Ref is A/46/21/OUT

Subject: Plan downsway heathfield comments from 45 downsway opposite corner of road

Owner:	Mr Kostas Povilaitis		
Project:	Land at Downs Way, East Preston Pair of Semi-Detached Bungalows		
Component:	Proposed Site Plan		
Note:	Rev.	Plan-No.:	CBL-0820225-PS101
Scale:	1 : 200	Date:	18/02/2021

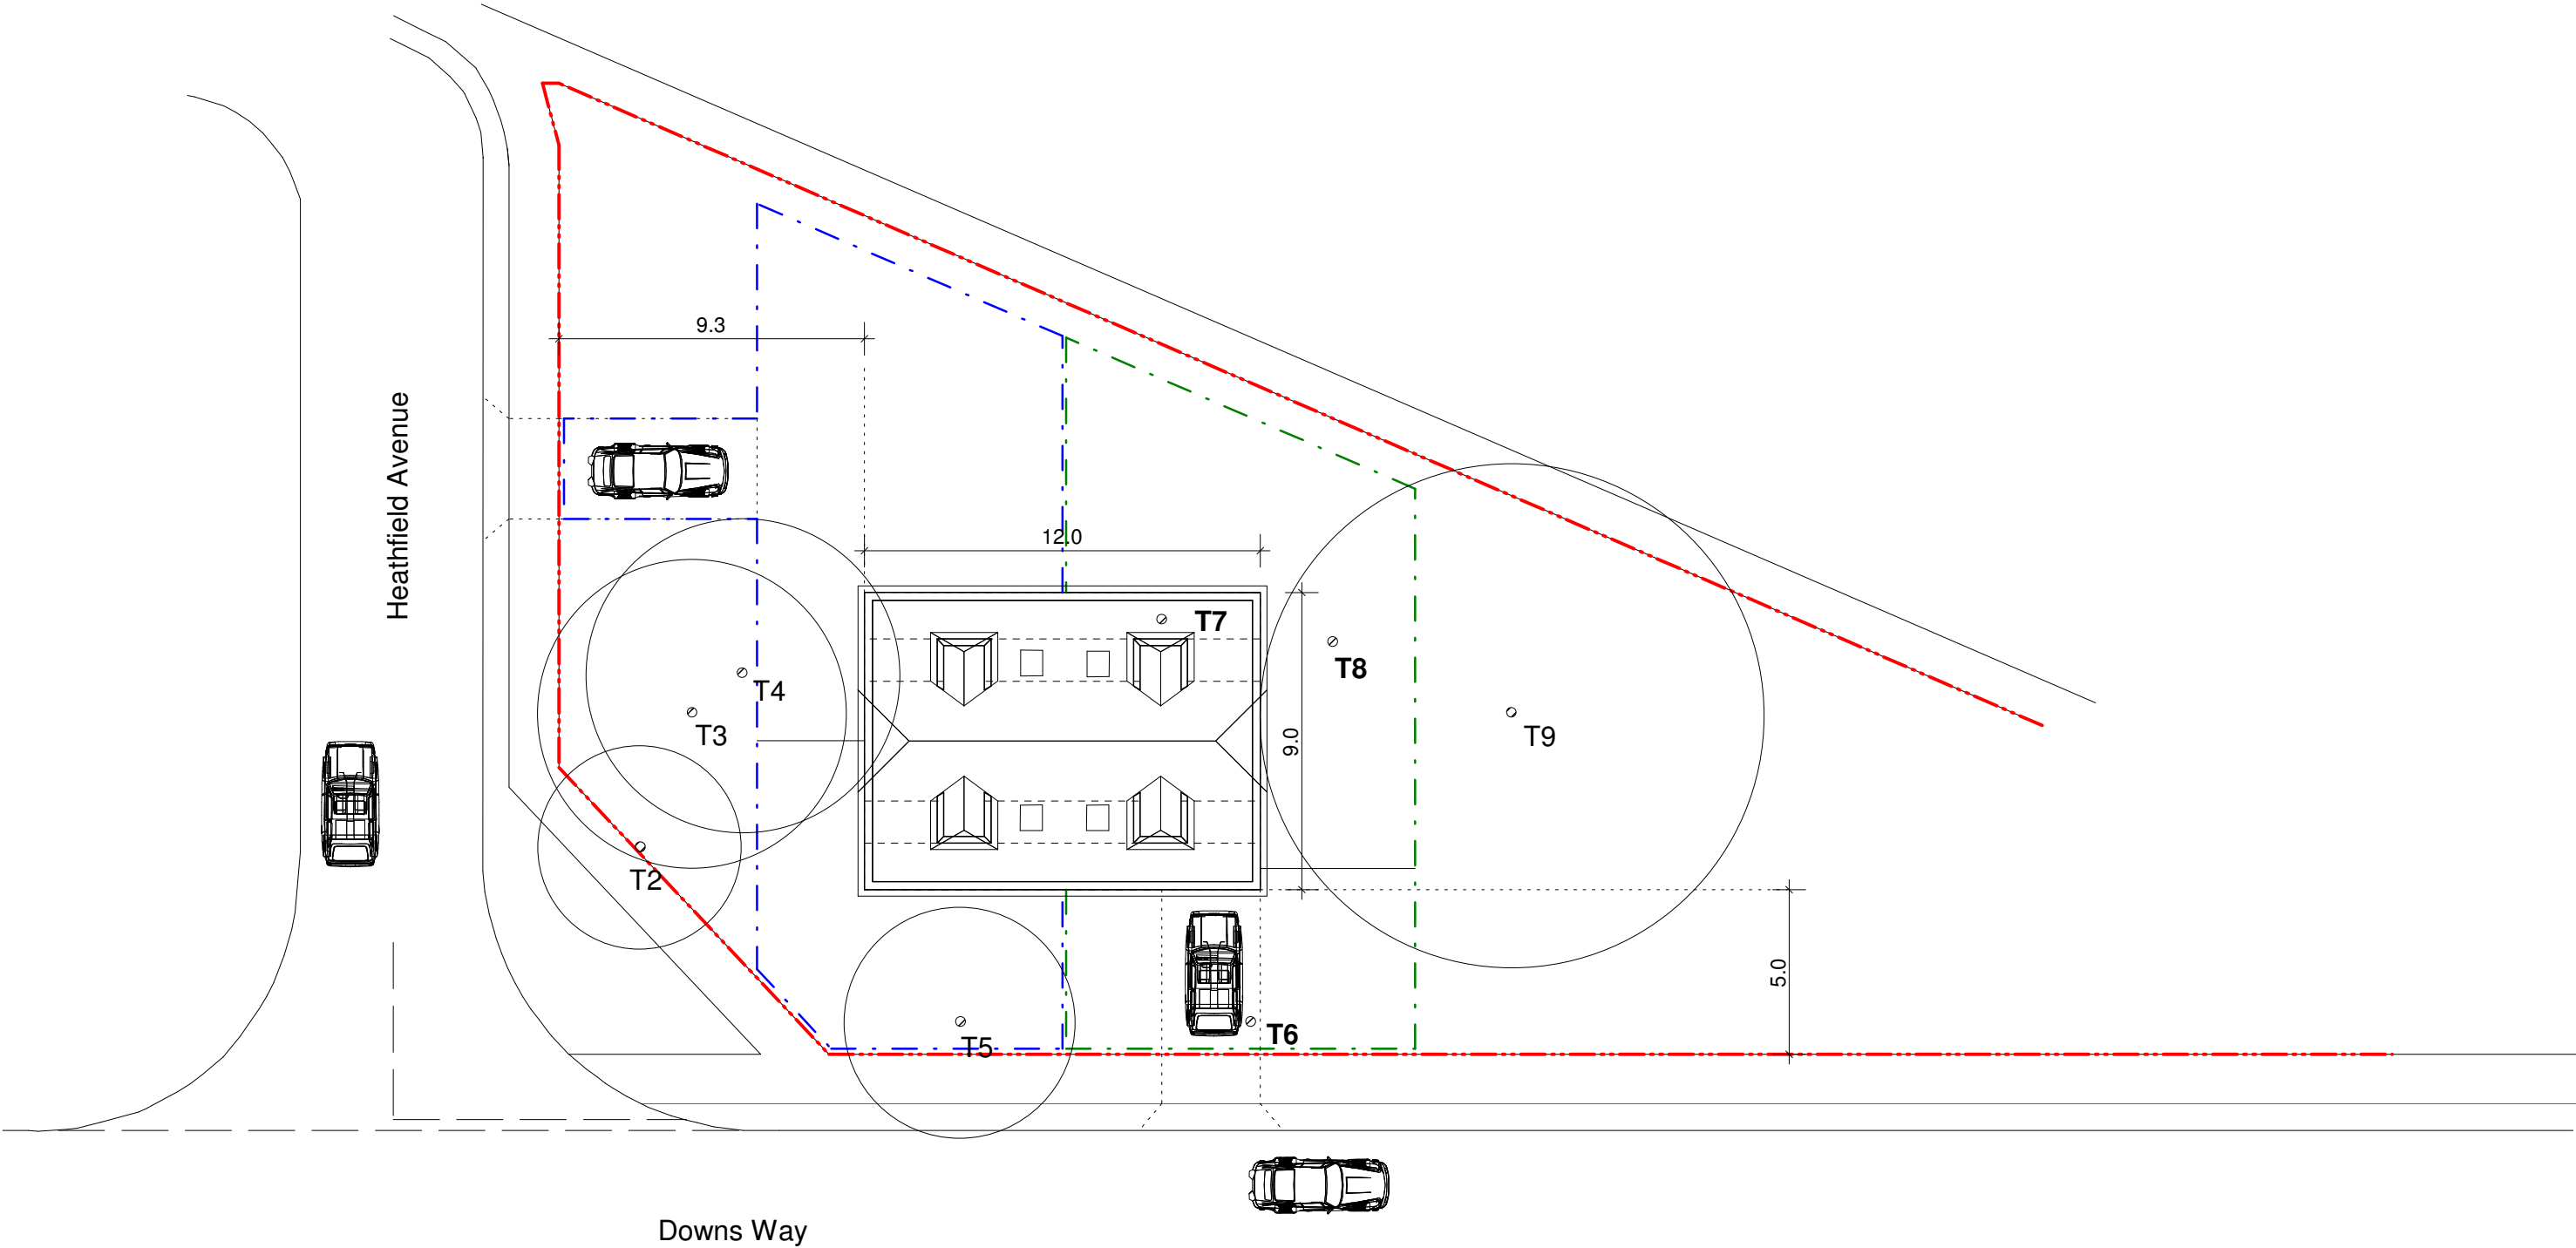
4 vehicle parking the drivers should be 2 cars and there would be concern for anymore at these properties as parking could not happen on downsway outside on their side of road so it would mean cars would then park outside mine and next dr in heathfield maybe causing trouble at junction or for us if visitors were to be leaving later at night as my bedrooms in front

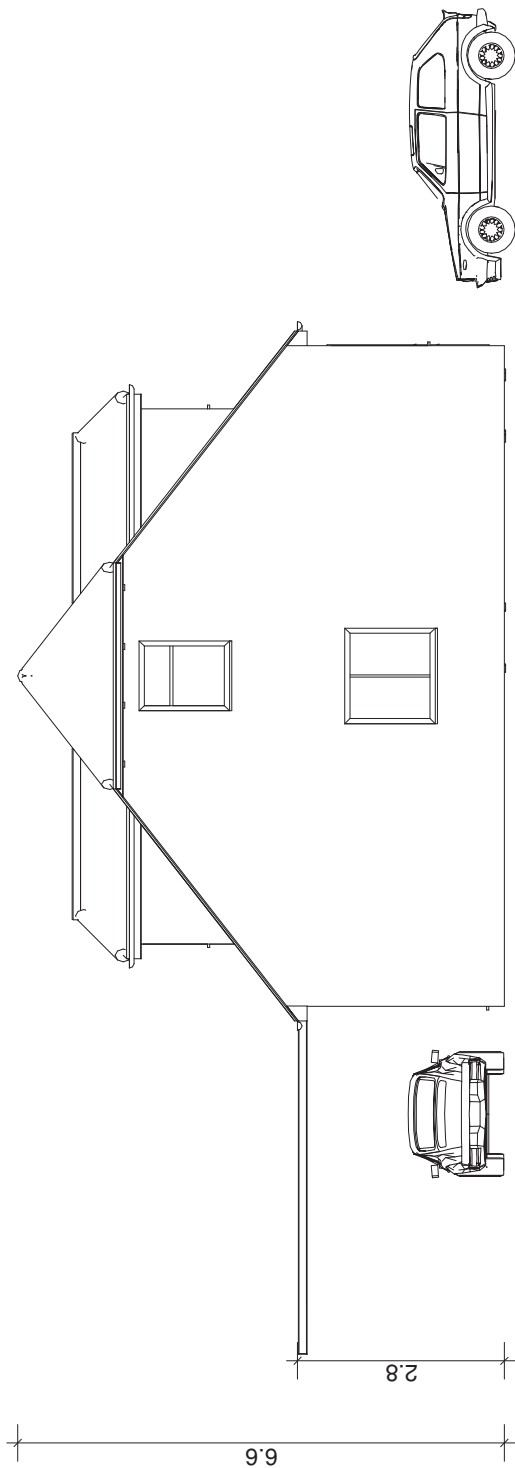
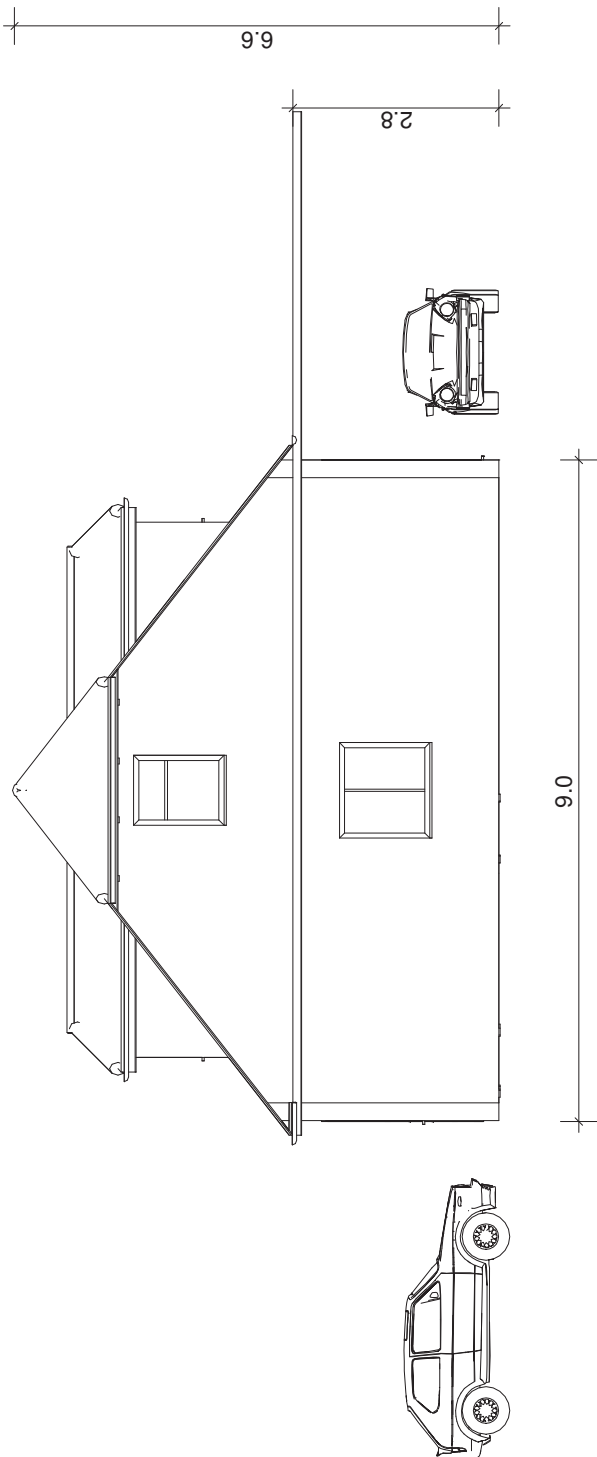
3 if the dwellings were to happen the windows overlooking from side of one into my bedrooms at 45 would be intrusive and interfere with my privacy unless these windows would be frosted or no windows as the building would be higher than a normal bungalow

Tree Protection Plan

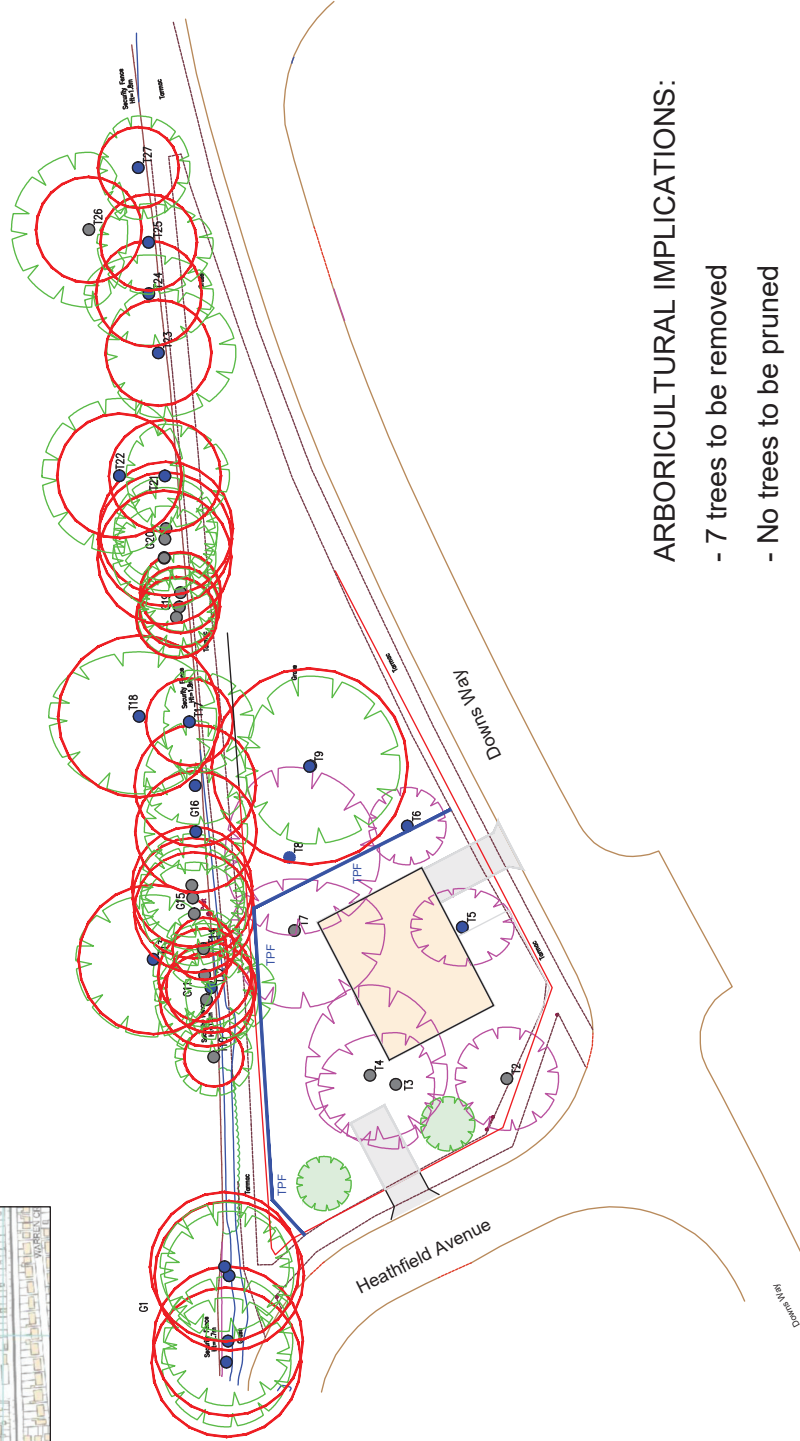
6 clearing of trees and shrubs the birds will be nesting soon also with the area cleared this will not happen in future for wildlife and 2 trees will hardly compensate and not make it feel like a green space with trees shrubs grass area when moving here it has been cut by west Sussex and thought belonged same came as shock when areas went up for auction as builder died and excuse tute s wanted to realise money didn't as probably a lot of residents in this road that these pieces would be lost or maybe from jean semmence 45 downsway
